Recommendation Report for Lawful Development Certificate for a Proposed Use or Development

REF NO: BR/292/18/CLP

LOCATION: Flat 14
Elizabeth Court
Park Terrace Bognor Regis

PROPOSAL: Lawful development certificate for the proposed replacing of windows.

# Authentic 147 Cross Sections

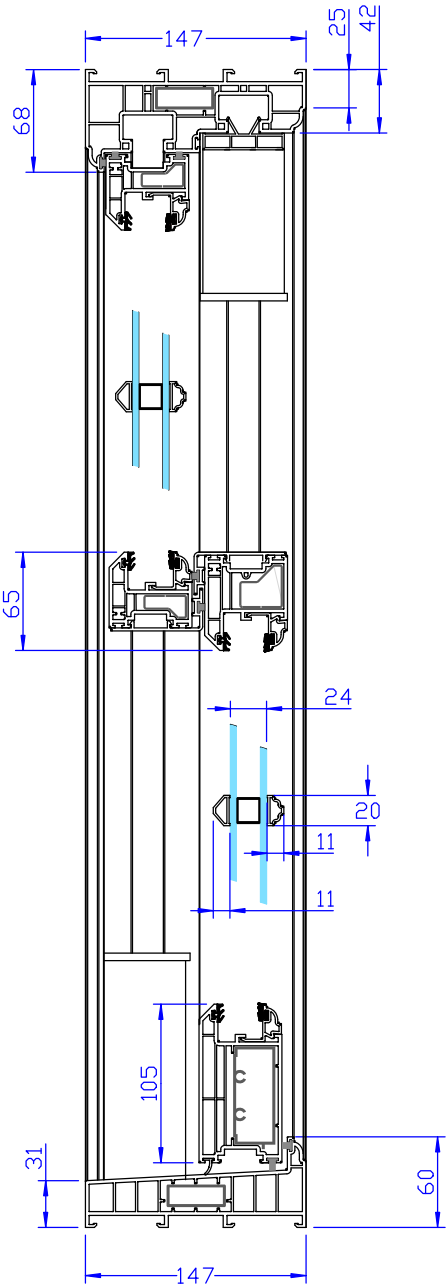
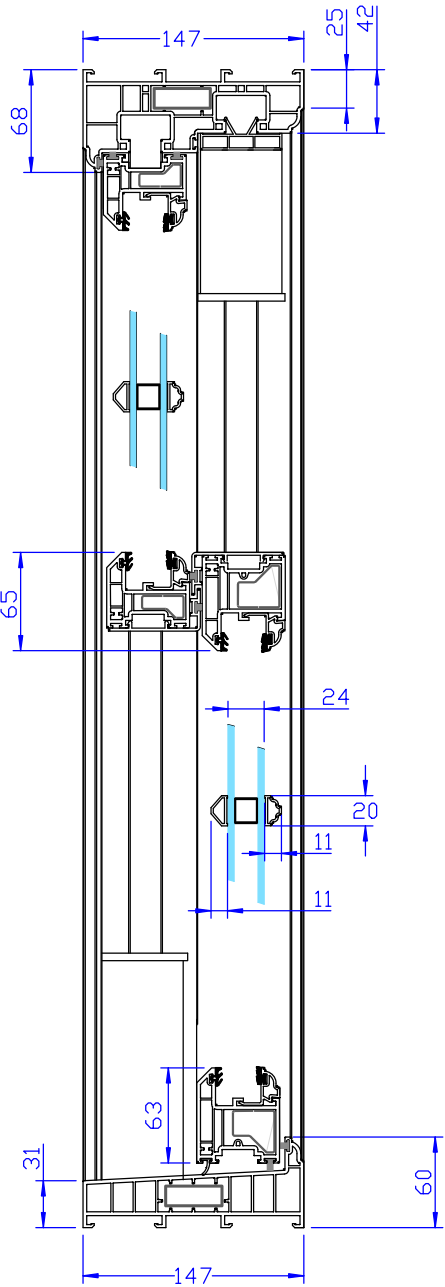
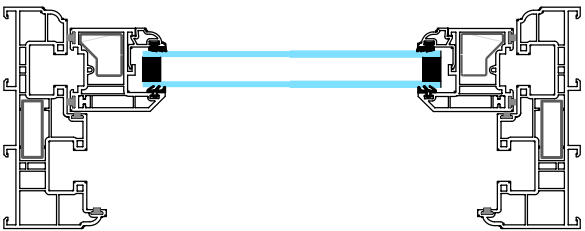
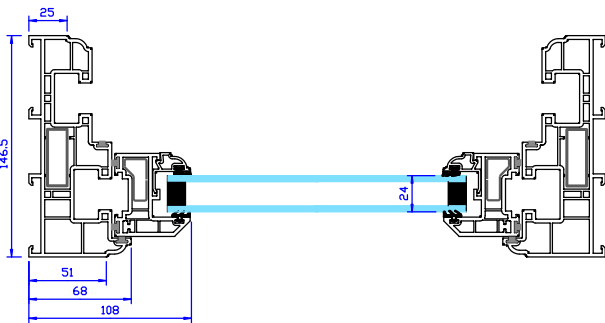
The Conservation Officer has indicated that the proposed replacement windows in this application would be materially different in appearance to those currently in situ. The intention is that the material of the replacement windows changes from wooden to UPVC, but that the existing opening arrangement is maintained. It is not clear if the dimensions of the proposed windows closely reflect those of the existing. If they do, this may result in them being acceptable from a visual perspective. However, from a purely conservation perspective the design and detailing of the proposed windows can make them appear different to traditional windows. Further, the visual effect of shiny modern plastic is out of keeping with more traditional materials.

The replacement windows are considered by virtue of the material proposed to appear different to traditional windows and are out of keeping with more traditional materials. Therefore, the proposal is considered to have a material impact on the external appearance of the dwelling, in conflict with Section 55 (2)(a)(ii) of the Town & Country Planning Act.
